DECISION NOTICE

Application Ref: EP/69/21/PL

4 Beechlands Close and
east of 18 Beechlands Court
Montpelier Road
East Preston
BN16 1JZ

1 No. 3-bed bungalow (resubmission following EP/10/21/PL). This site is in CIL Zone 4 & is CIL Liable as new dwelling.

Client	Description
c/o RSP ARCHITECTS LTD	PROPOSED PLANS, ELEVATIONS & SECTION

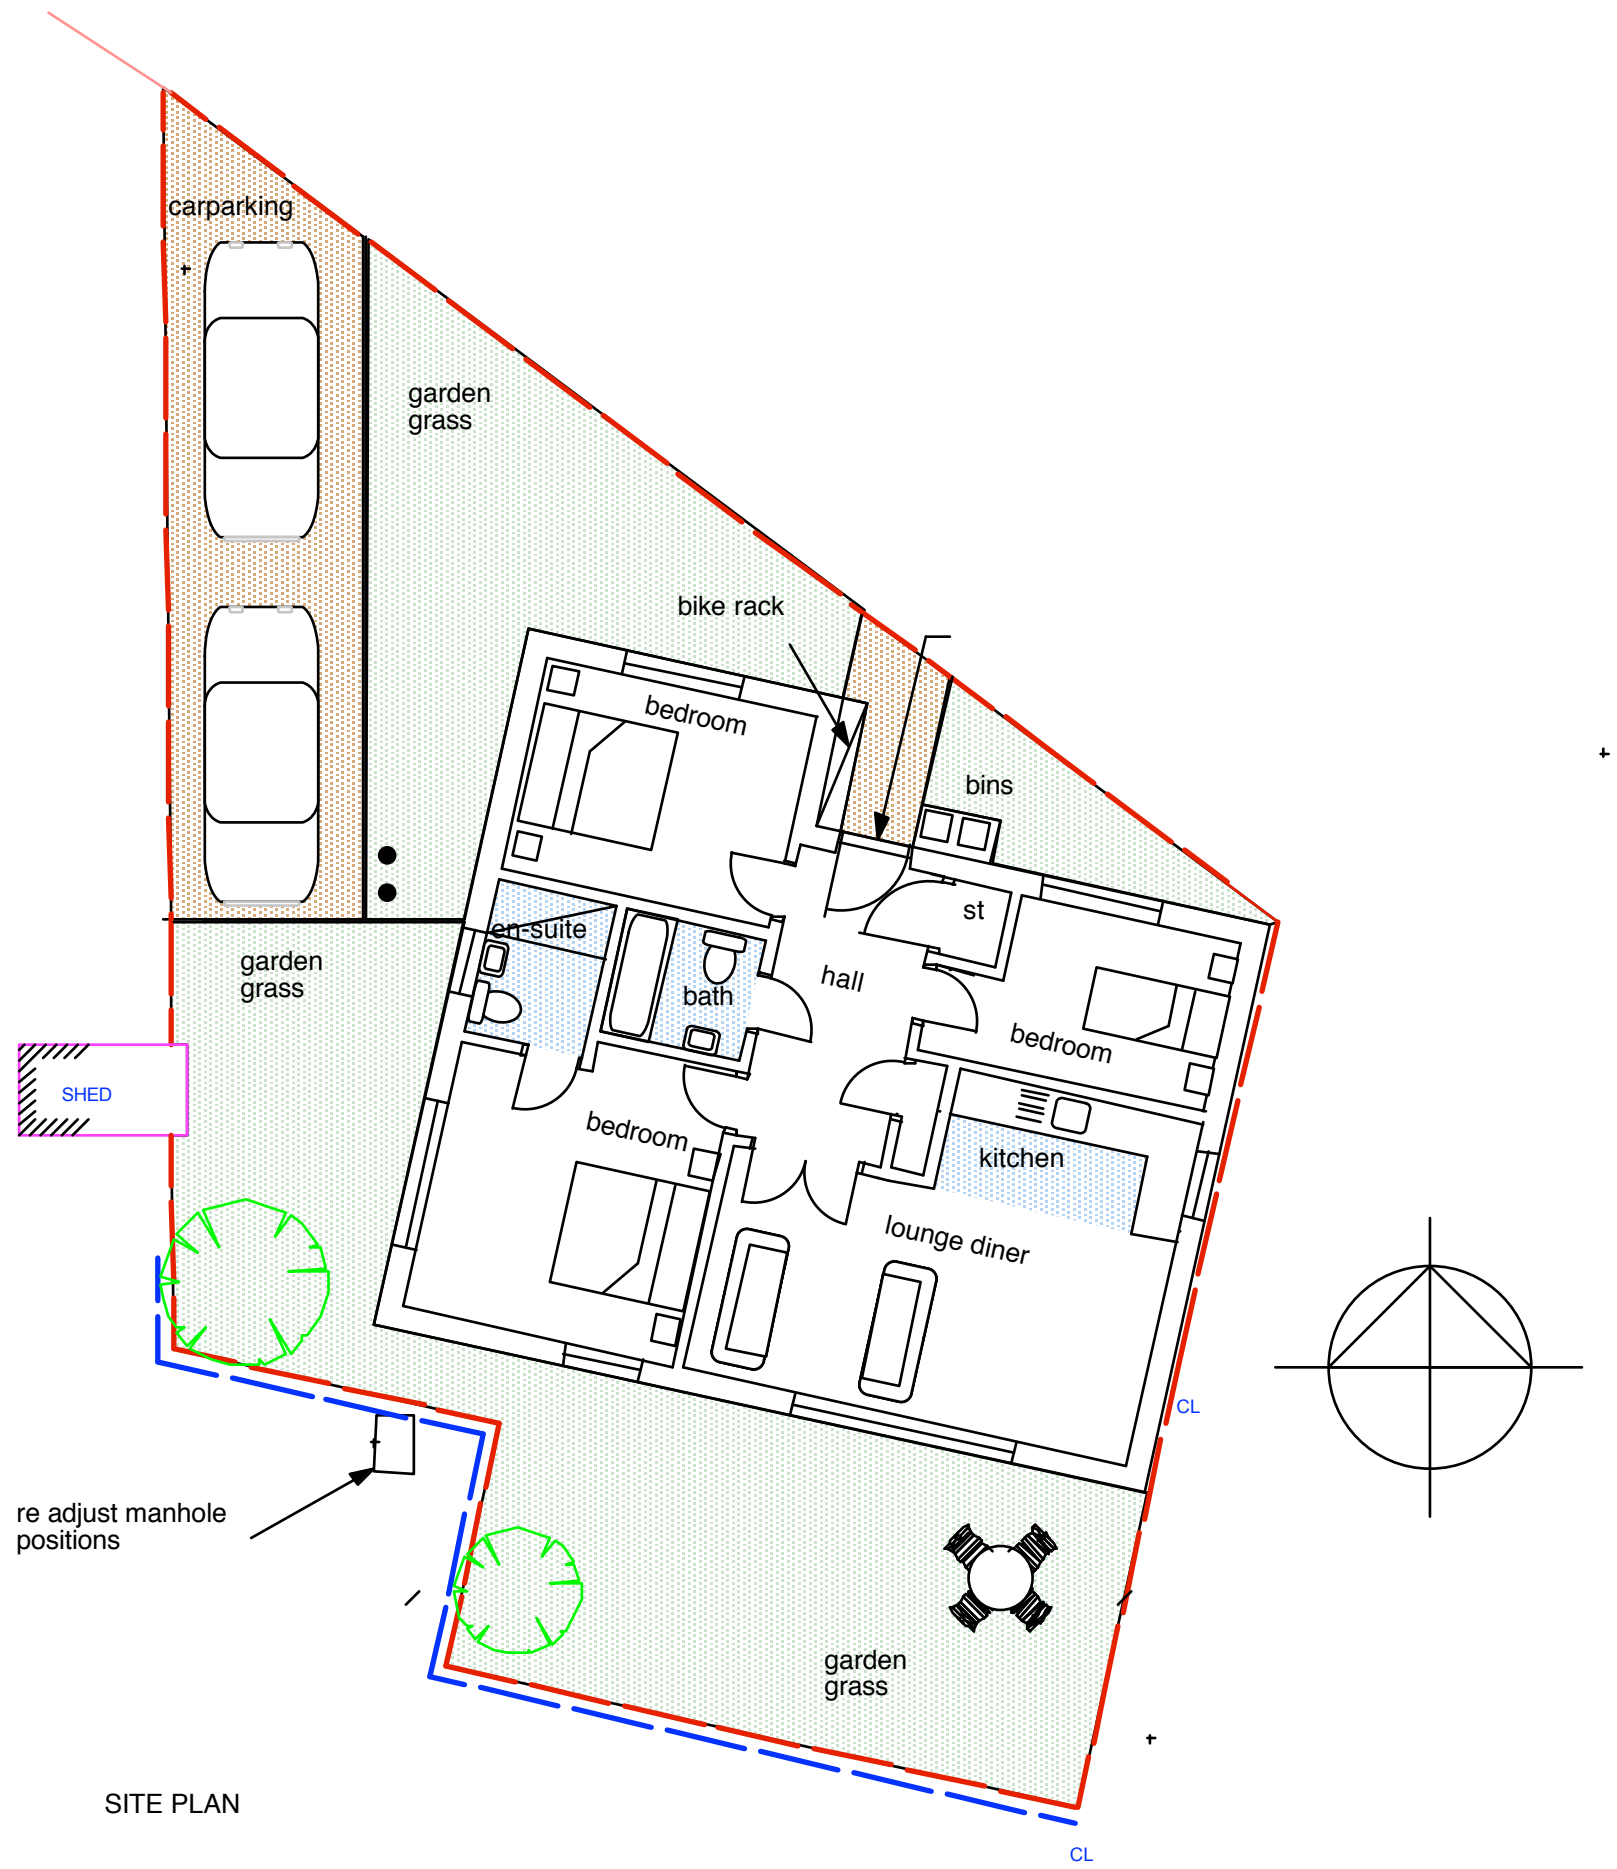
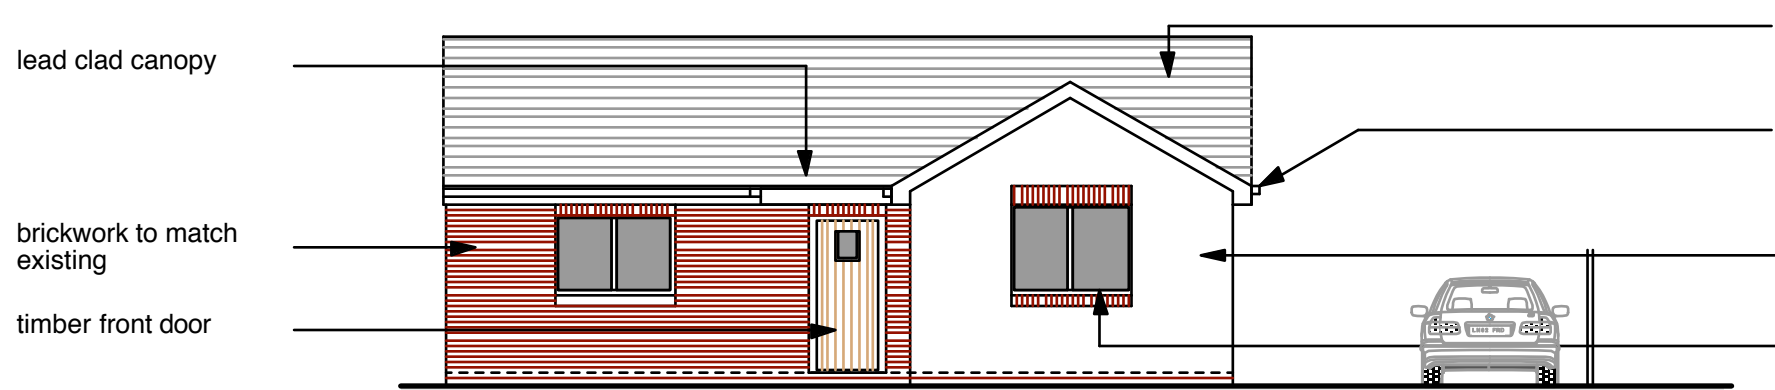
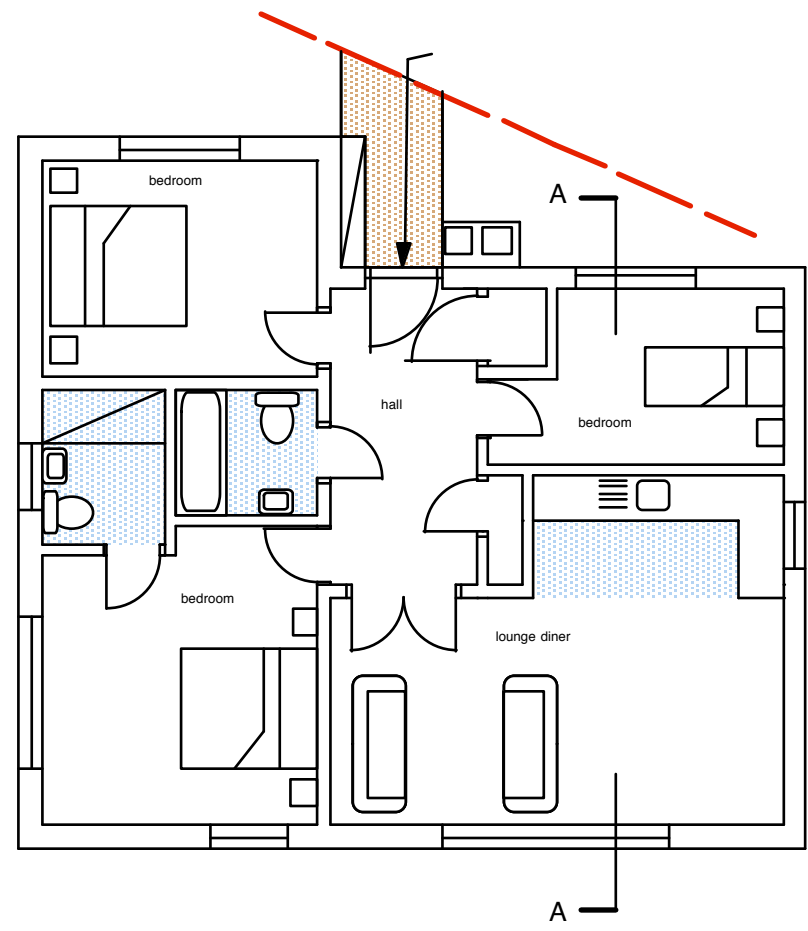
- 1 Given the size, footprint, forward position and lack of distance to site boundaries the bungalow would result in a cramped and overdeveloped appearance out of keeping with its surroundings in conflict with policies D DM1 and D SP1 of the Arun Local Plan, Part P of the Arun Design Guide and policy 1 of the East Preston Neighbourhood Plan.
- 2 The proposal is contrived in design and the limited and awkwardly shaped amenity space and lack of internal space would result in a form of development which would be detrimental to the residential amenities of future occupiers and results in a form of development that does not enhance the quality of the environment for prospective occupiers contrary to policies D DM1(15) and QE SP1 of the Arun Local Plan and Part H of the Arun Design Guide and the Nationally Described Space Standards.
